**Application by SP Manweb for an Order Granting Development Consent for the Reinforcement to the North Shropshire Electricity Distribution Network**

**Canal & River Trust Response submission for deadline two**

**Reinforcement to the North Shropshire Electricity Distribution Network (NSIP at examination)**

**Waterway: Montgomery Canal**

### **Montgomery Canal Crossing**

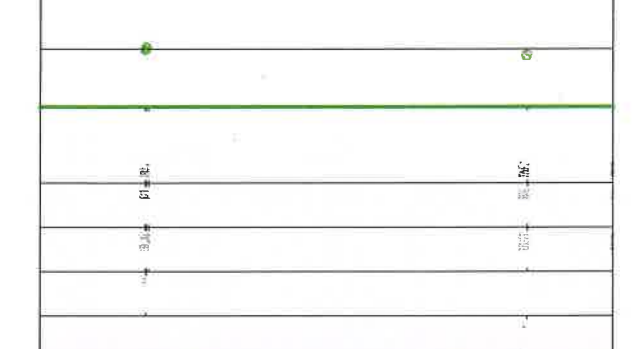
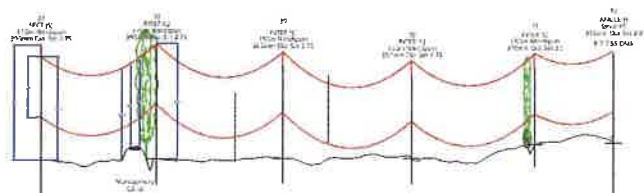
If the line were to be installed underground between poles 36 & 40, rather than overhead, what would the short/long term construction impacts of these works be on the canal and its environment? What access would be required for what kinds of equipment and would this result in any loss of vegetation or other visual impacts? How would it be constructed and what visual and structural impacts would this have on the canal in the short and long term? How would the canal be protected from damage or leakage during construction? Would any stoppages be required and if so for how long and why (and how would this compare with any requirements for the installation of the overhead line)?

Where the overhead proposals show that there would be a loss of the existing landscaping either side of the canal we ask whether this would be retained if the poles were to be located underground instead, and whether there would be any other loss of other landscaping for associated reasons? Has there been any assessment of whether the terminal poles at 36 & 40 would be visible from the canal and if so, whether this impact is acceptable (and if so, please provide it)? Has there been any assessment of the visual impact on the canal and its users of the proposed alternative access track that would be required if the line was to be underground, and if so, please provide it?
